# CITY OF ALBUQUERQUE

May 2, 2023

**Re: Santa Barbara/ Martineztown Multigeneration Center**  
**1825 Edith Blvd. NE**  
**Traffic Circulation Layout**  
Engineer's Stamp 04-05-23 (H15-D070)

SITE PLAN

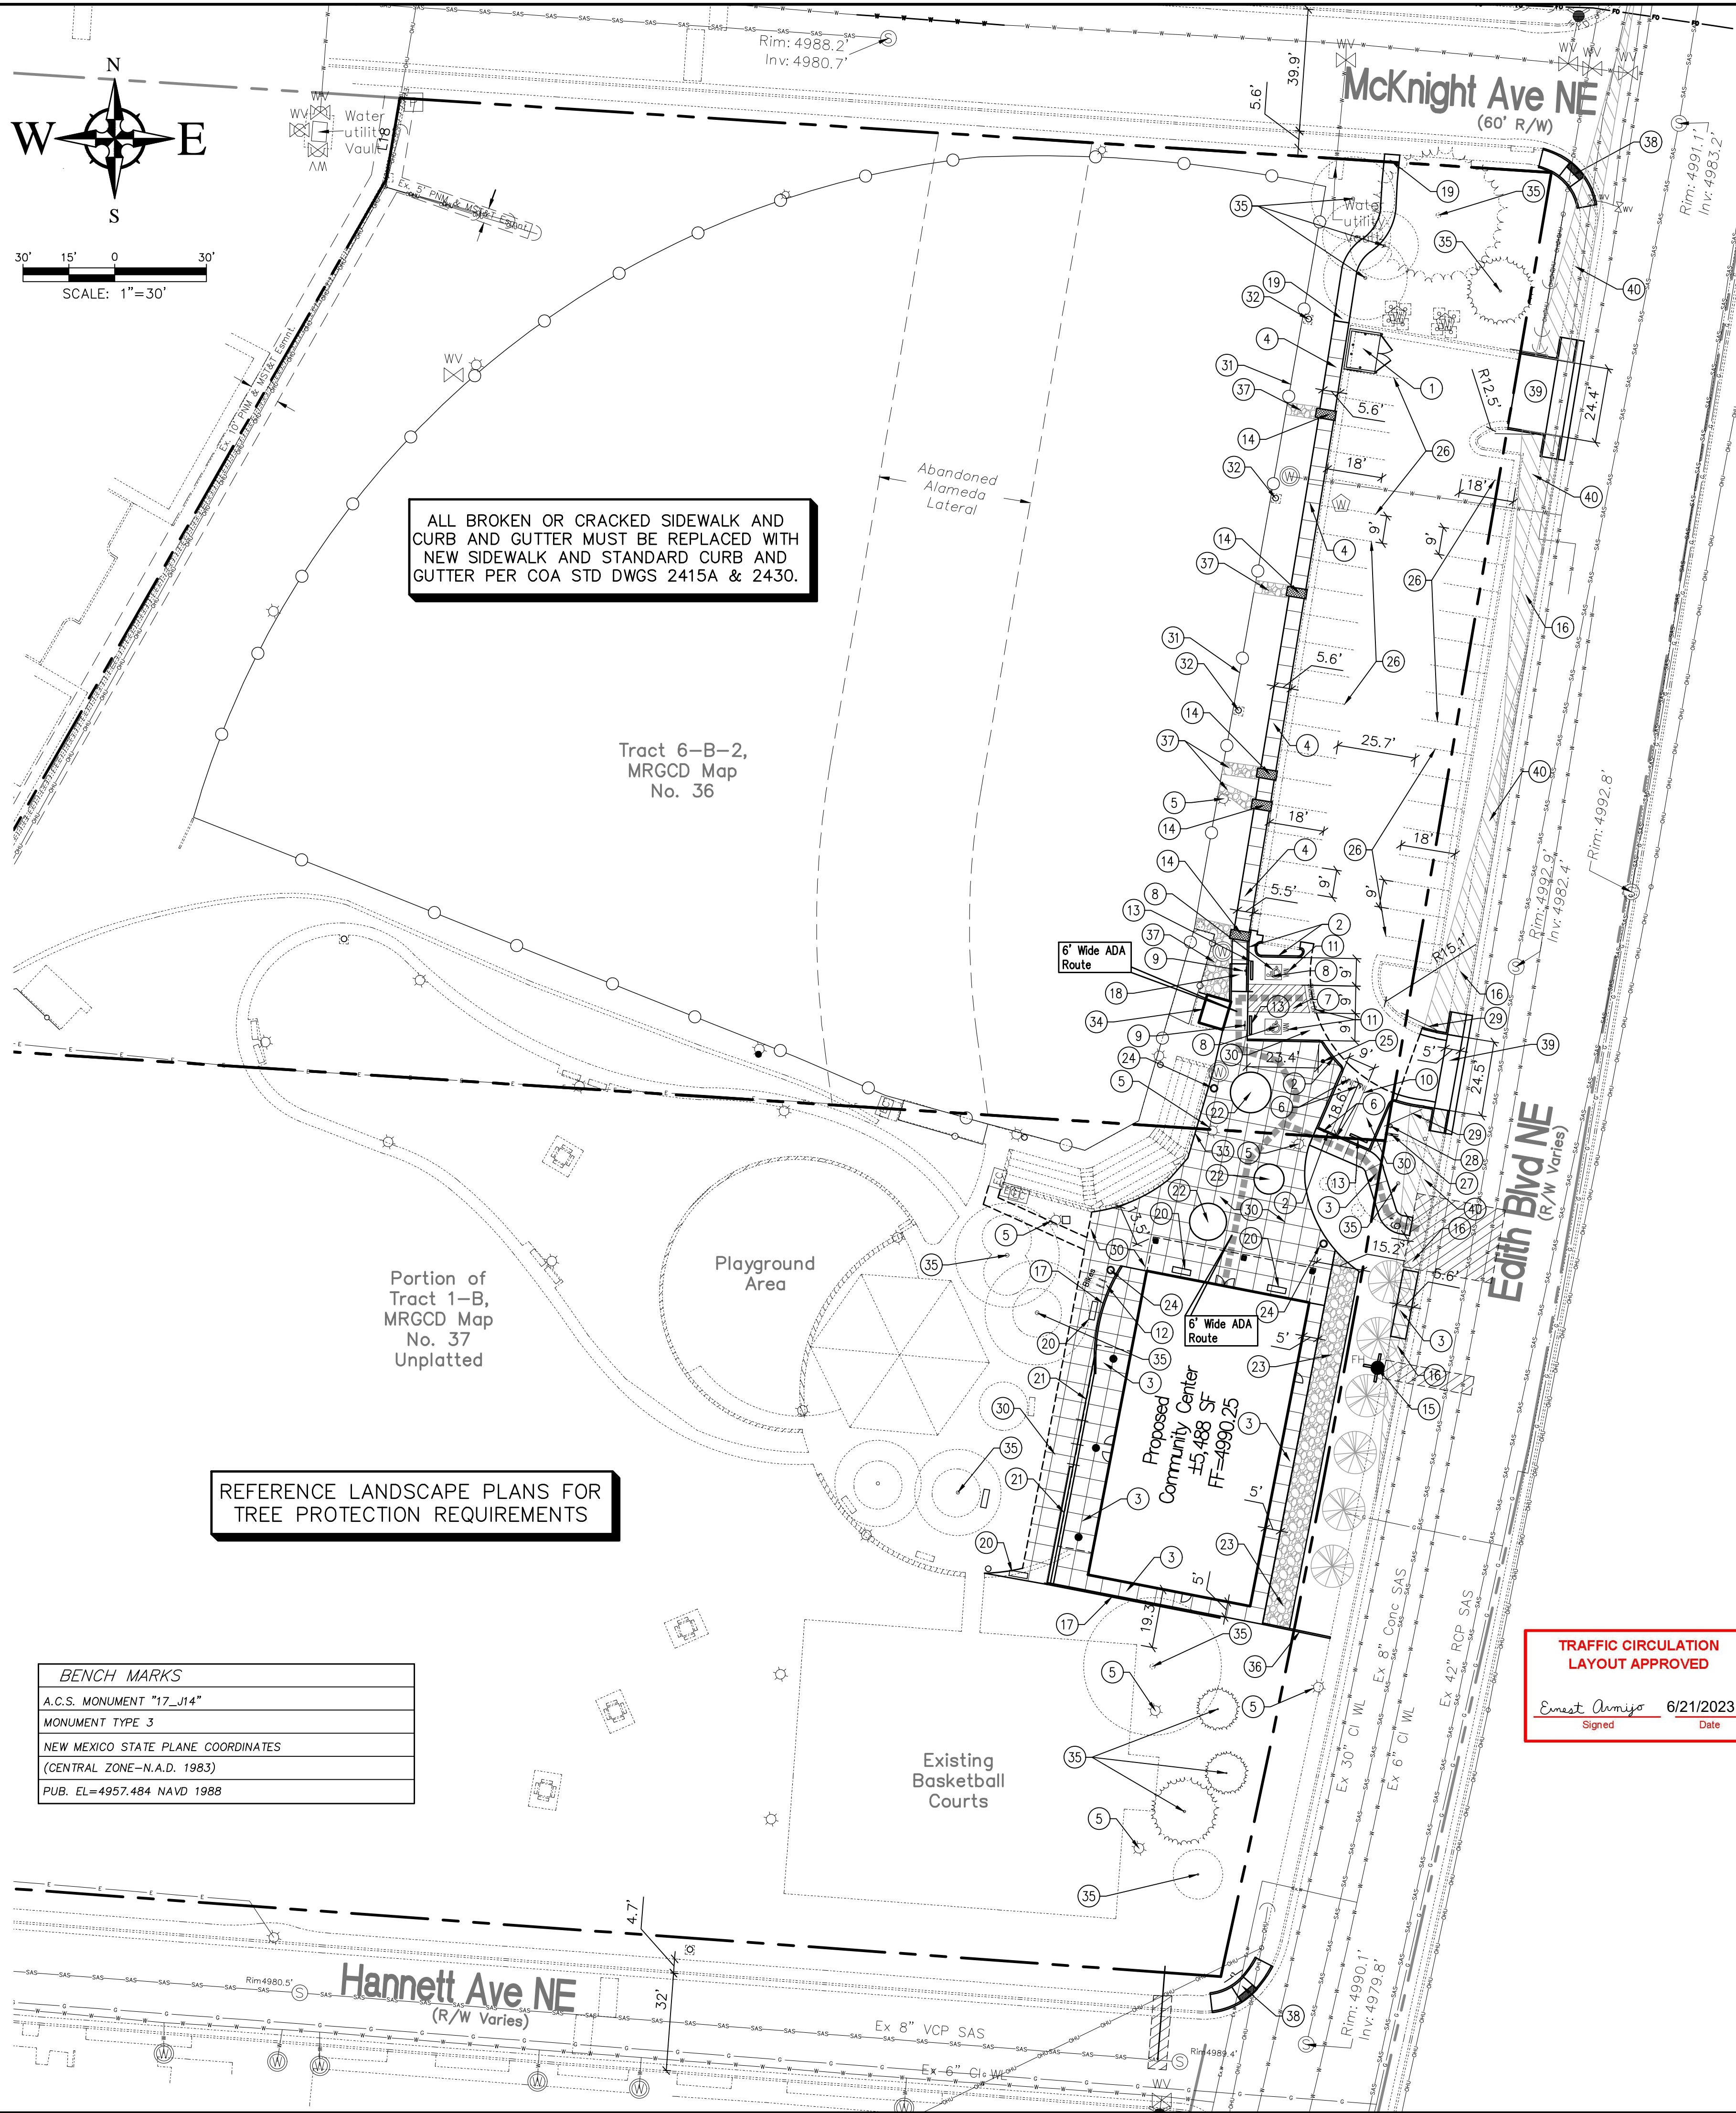
1. List the number of parking spaces required by the IDO as well as the proposed number of parking spaces including bicycle and motorcycle parking.
2. Identify all existing access easements and rights of way width dimensions.

3. Identify the right of way width, medians, curb cuts, and street widths on McKnight Ave.
4. Please update both site accesses to current ADA standard and reference city standard.

5. Site plan shows a property line in the middle of the site, but GIS and IDO maps show it's one whole site. Please clarify why the site plan has a property line in the middle of the site.

6. Please list the width and length for all existing and proposed parking spaces. Some dimensions are not shown.
7. The ADA access aisles shall have the words **"NO PARKING"** in capital letters, each of which shall be at least one foot high and at least two inches wide, placed at the rear of the parking space so as to be close to where an adjacent vehicle's rear tire would be placed. (66-1-4.1. B NMSA 1978)

8. ADA curb ramps at the corner of Edith Blvd. & Hannett Ave. and Edith Blvd. & McKnight Ave. must be updated to current standards and have truncated domes installed.

9. Motorcycle parking spaces shall be designated by its own conspicuously posted upright sign, either free-standing or wall mounted per the zoning code.

10. The pavement marking "MC" should be shown in the opposite direction for motorcycles entering the parking space.
11. Keynote 12: please clearly show the Bike Racks on the site plan and provide details.

16. Per DPM, a 6 ft. wide ADA accessible pedestrian pathway is required from the ADA parking stall access aisles to the building entrances. Please clearly show this pathway and provide details.

17. ADA accessible pedestrian pathway should not be placed behind parking space or adjacent to a vehicular way. Vehicle and pedestrian/wheel chair conflicts should be avoided as much as possible.

18. Refuse vehicle maneuvering shall be contained on-site. The refuse vehicle shall not back into the public right of way.; provide a copy of refuse approval.

19. Provide a copy of Fire Marshal approval.
20. Show the clear sight triangle and add the following note to the plan: "Landscaping and signage will not interfere with clear sight requirements. Therefore, signs, walls, trees, and shrubbery between 3 and 8 feet tall (as measured from the gutter pan) will not be acceptable in the clear sight triangle.

BIKE RACK (Typ)

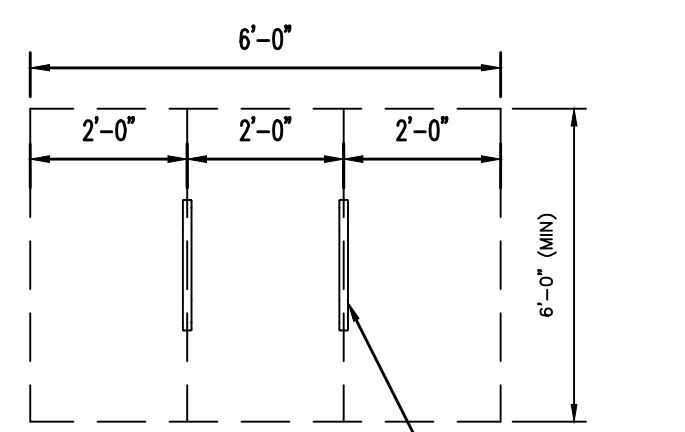
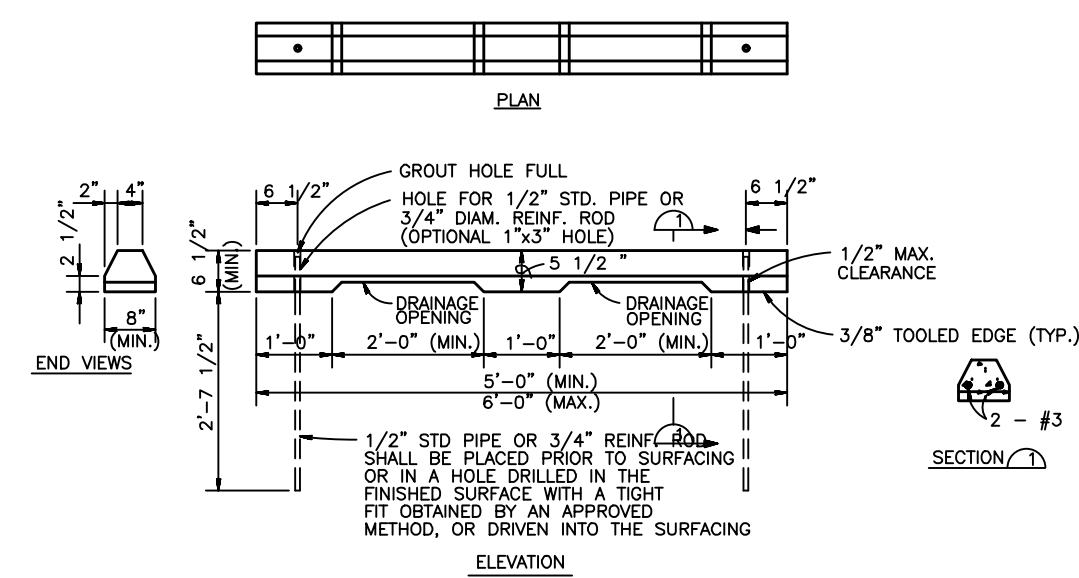
12. All bicycle racks shall be designed according to the following guidelines:
  - a. The rack shall be a minimum 30 inches tall and 18 inches wide.
  - b. The bicycle frame shall be supported horizontally at two or more places. Comb/toaster racks are not allowed.

- c. The rack shall be designed to support the bicycle in an upright position. See the IDO for additional information.
  - d. The rack allows varying bicycle frame sizes and styles to be attached.

- e. The user is not required to lift the bicycle onto the bicycle rack.
  - f. Each bicycle parking space is accessible without moving another bicycle.

13. Bicycle racks shall be sturdy and anchored to a concrete pad.
14. A 1-foot clear zone around the bicycle parking stall shall be provided.
15. Bicycle parking spaces shall be at least 6 feet long and 2 feet wide.
